CITY OF ALBUQUERQUE

Re: Duplex Addition at 5321-Marble NE, Traffic Circulation Layout,
Engineer's Stamp dated 04-29-11 (J18-D040)

Re: **5321 Marble St. NE Duplex Addition**
Grading and Drainage Plan
Engineer's Stamp date 4-27-11 (J18/D040)

GRADING AND DRAINAGE PLAN

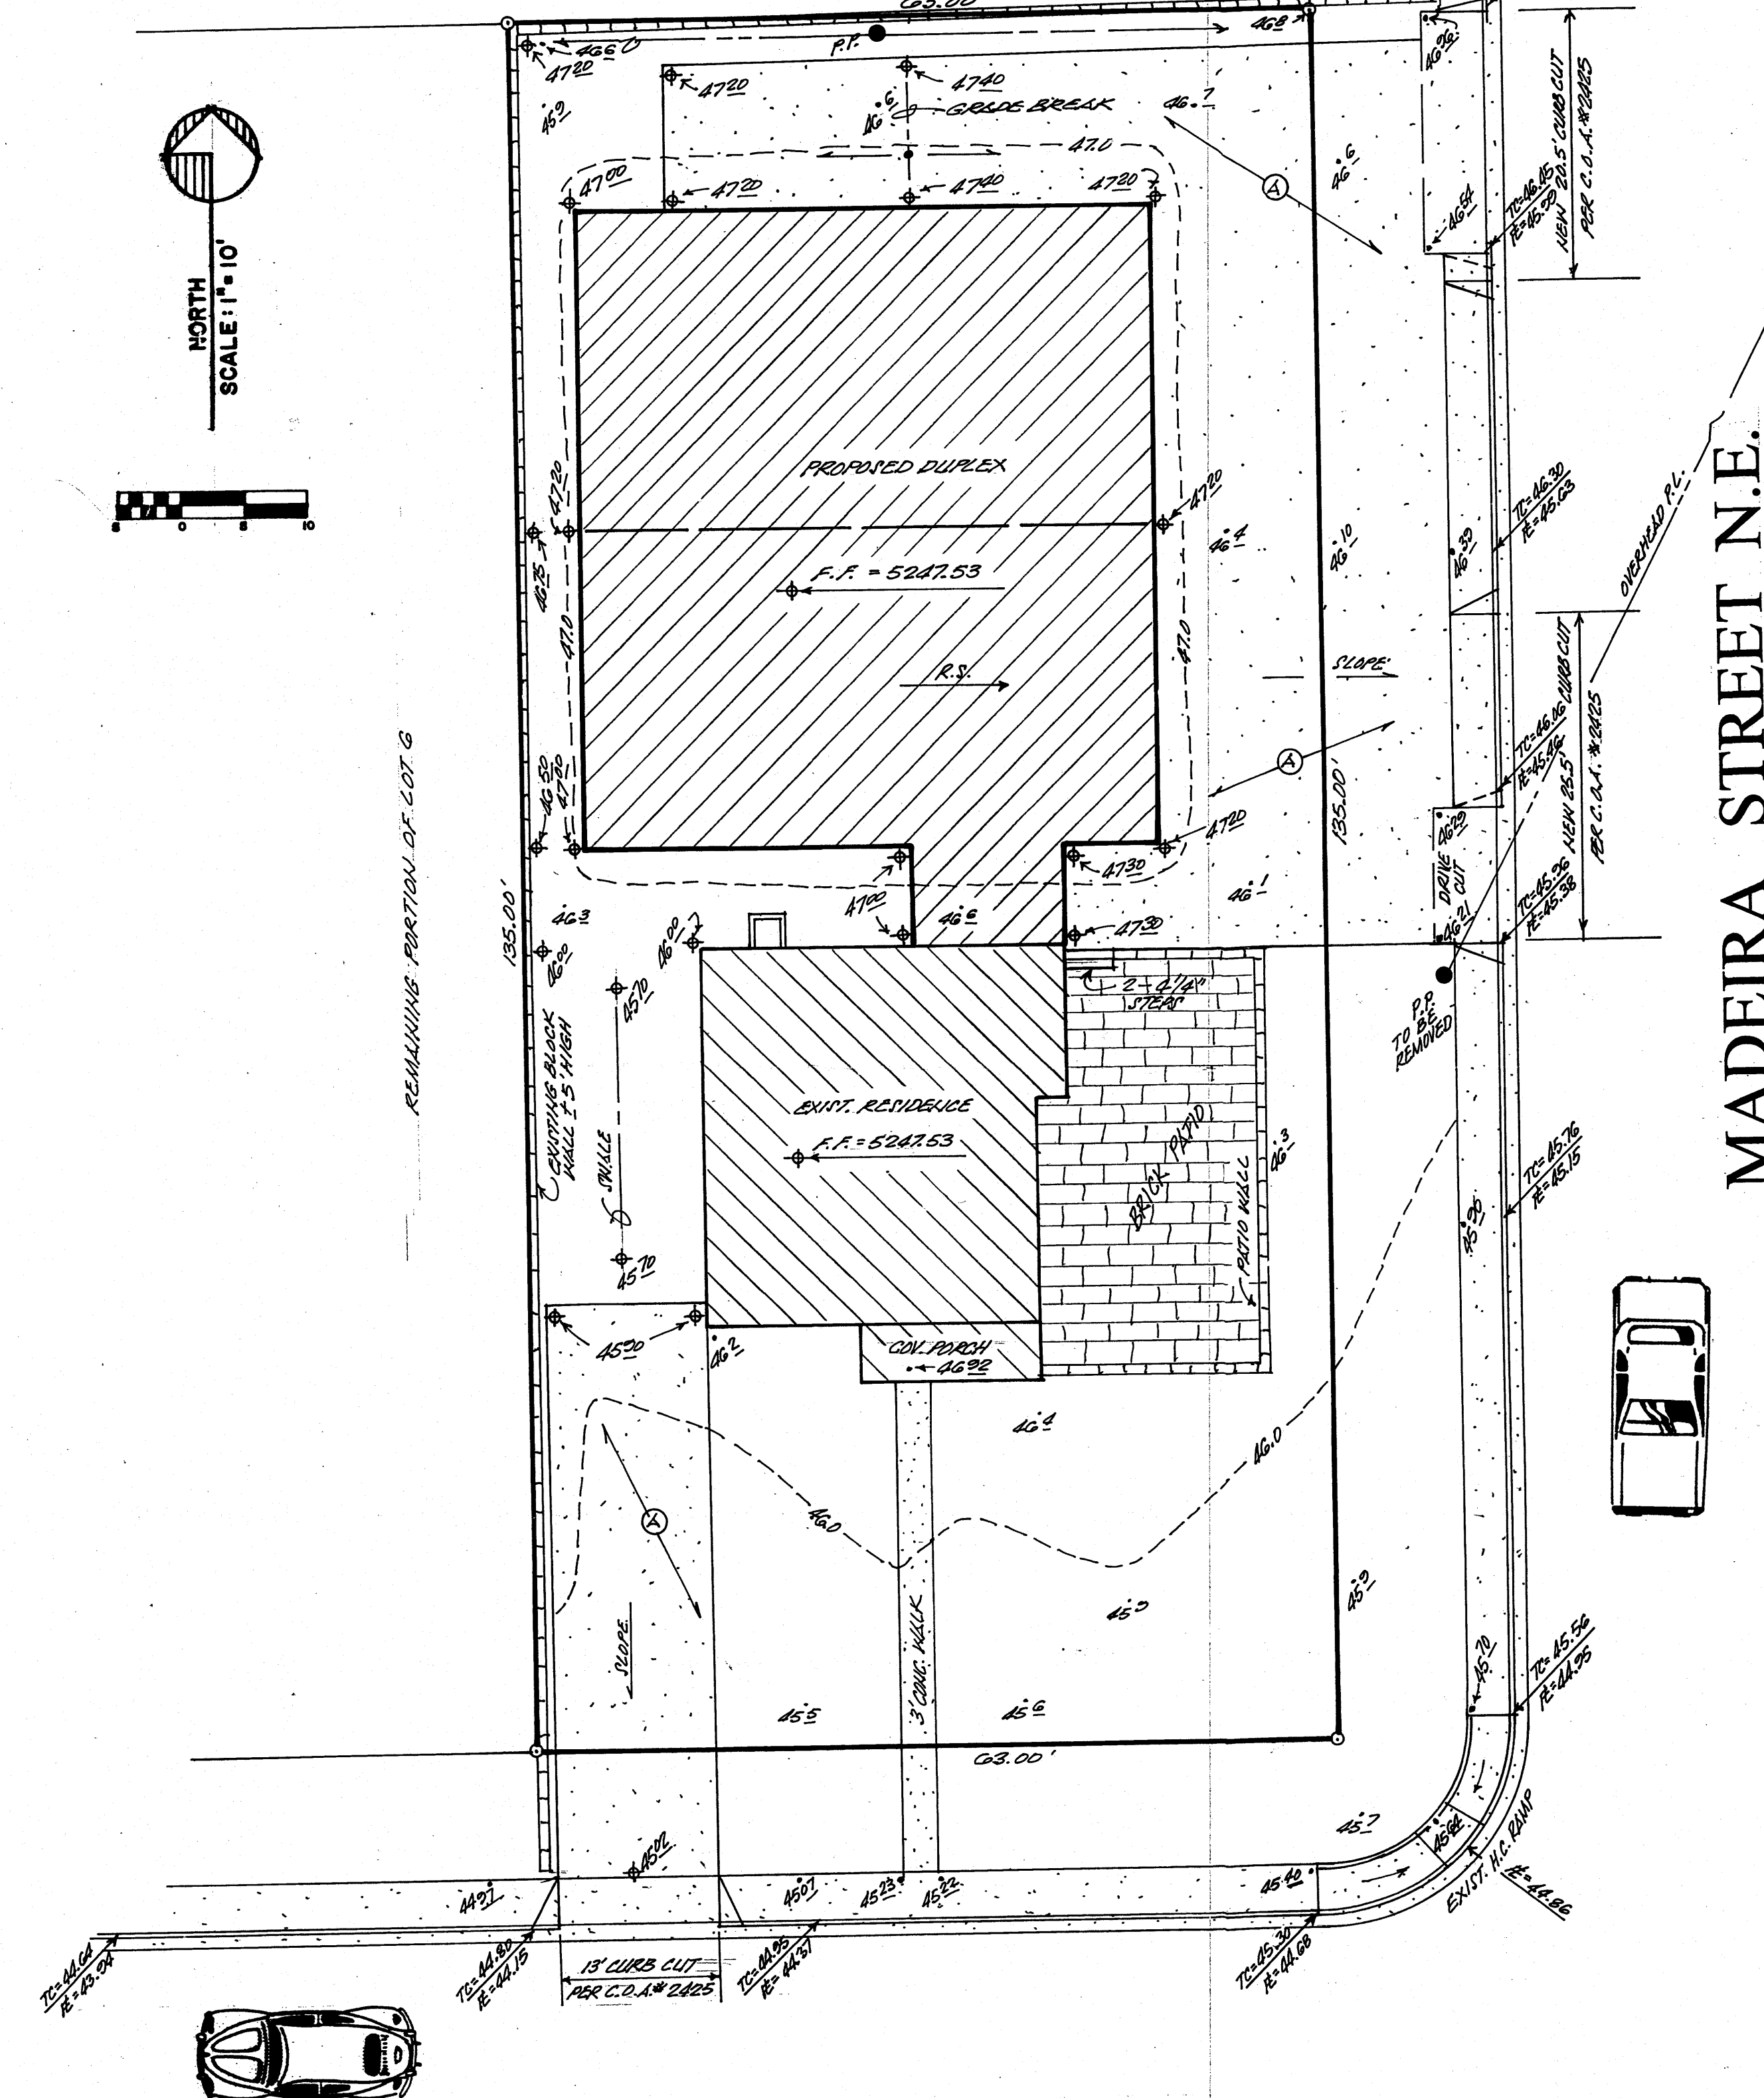
Ensure that new roof slopes to the east, to prevent flows heading towards the west (back yard).
